Our Ref: H/2/12/L

23rd February 2012

**Application for Listed Building Consent for various internal alterations & renovation of existing hardwood, double-glazed conservatory (this application lies within the South Downs National Park Authority)
2 St Nicholas Cottages The Street Houghton**

Drawing Title:
Conservatory

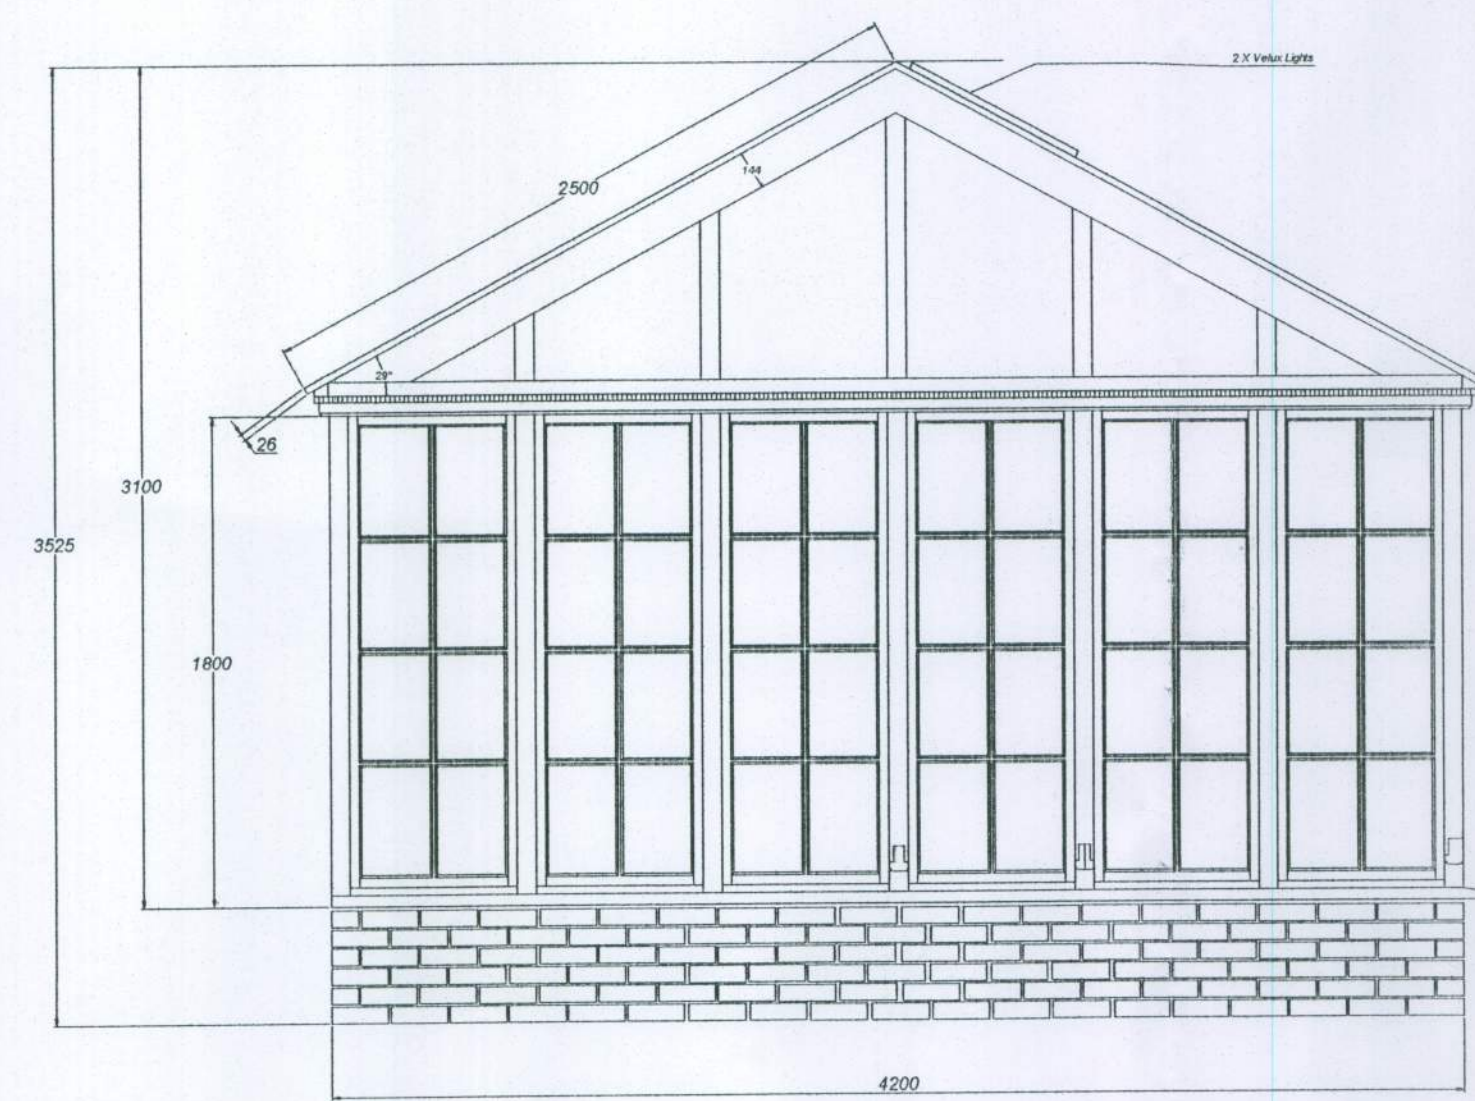
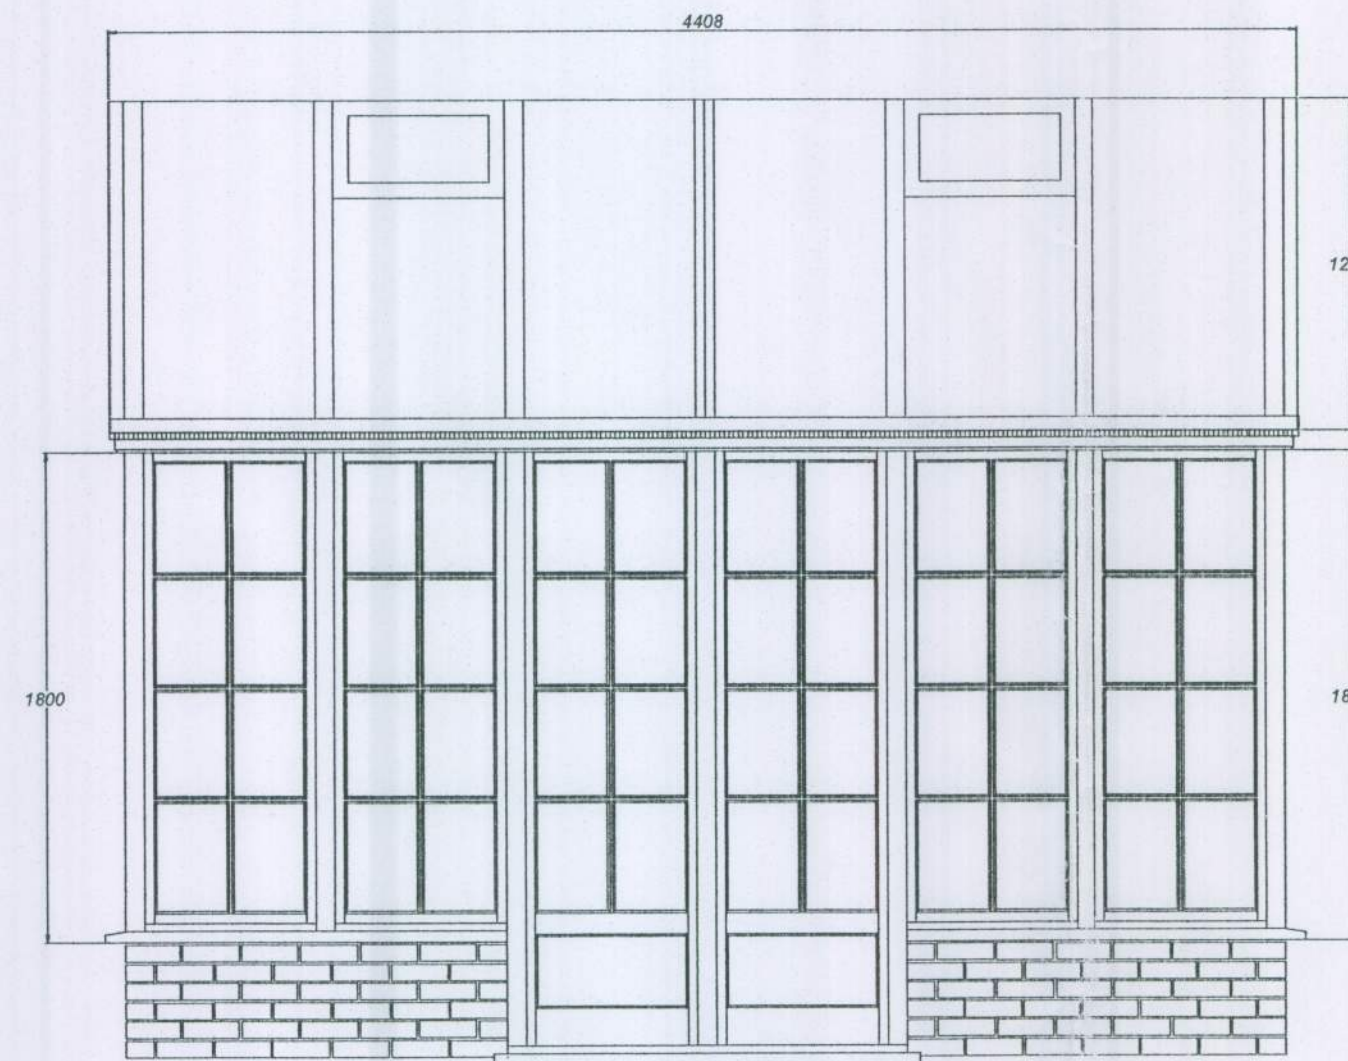
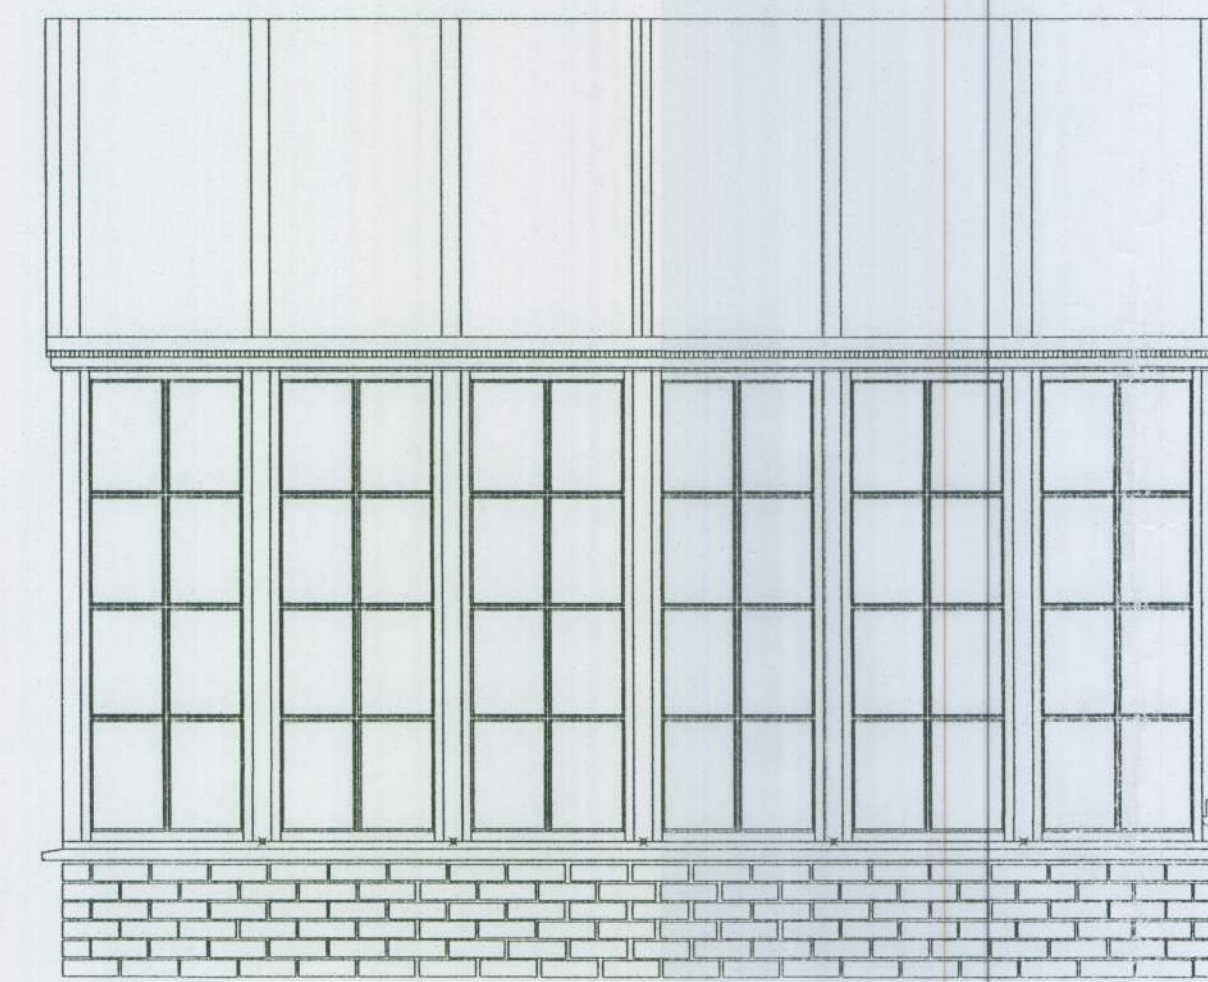
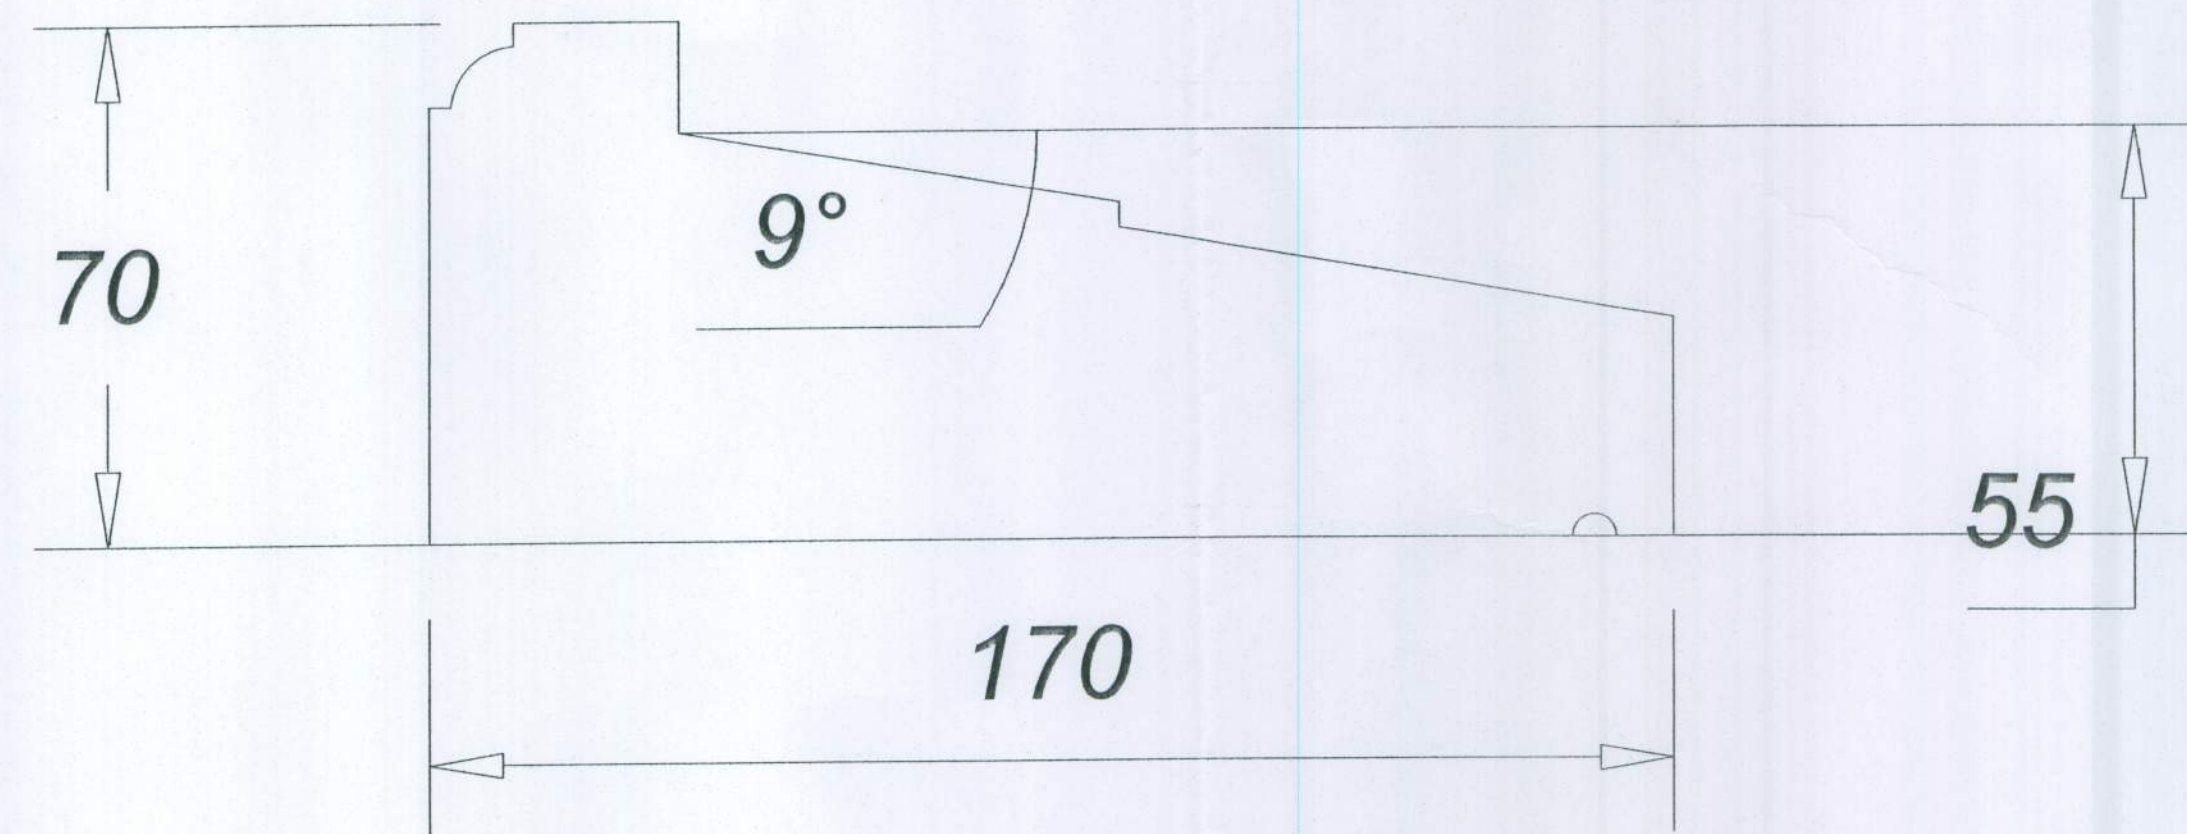
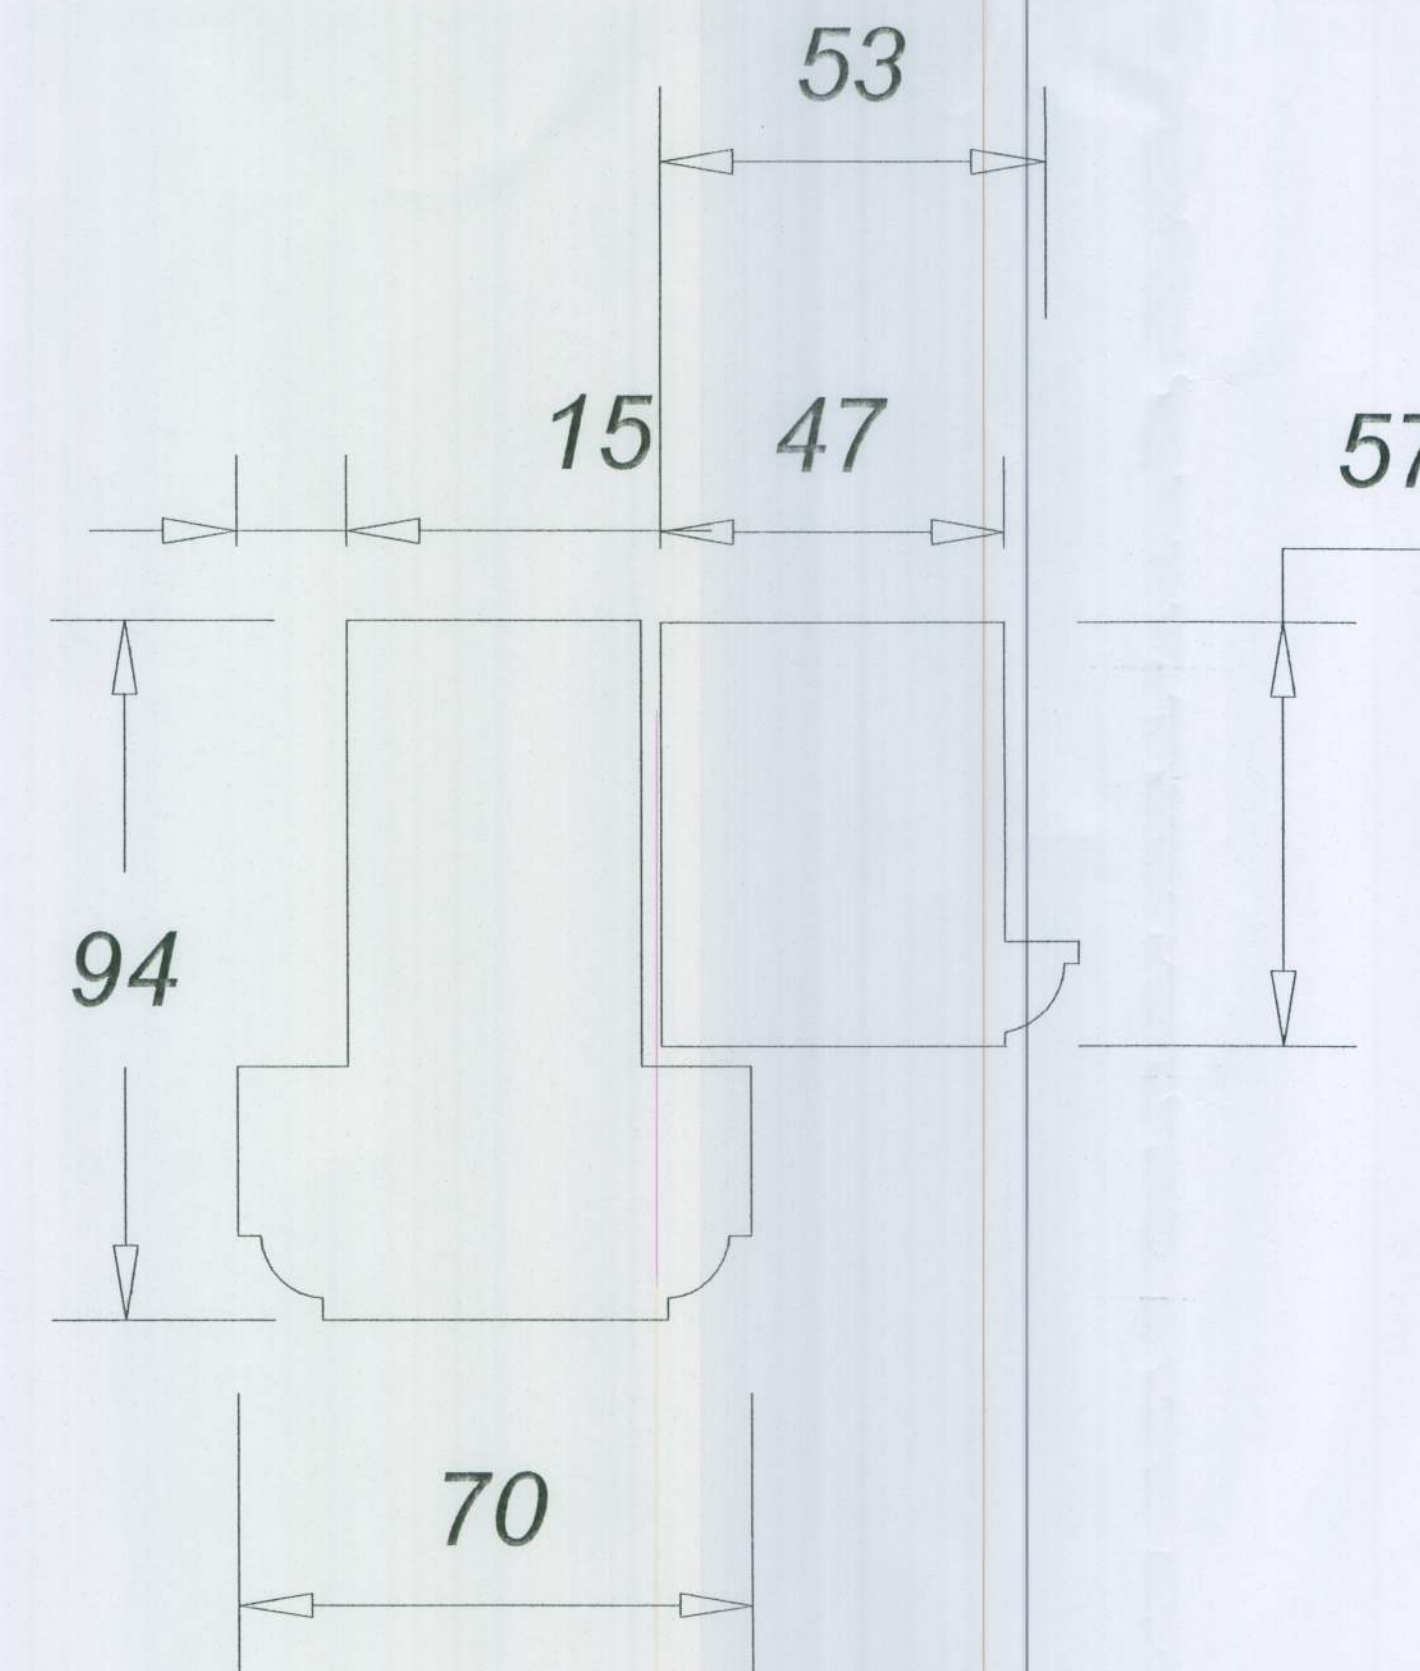
Please provide 1 electronic or 3 paper copies of existing and revised proposed elevations to show the conservatory in context with the dwelling house at a scale of 1:100 or 1:50.

Photo 1 shows the existing wooden conservatory that we are requesting to replace with the same style, height, footprint - but if possible using solar glass (sample of which is with the application)
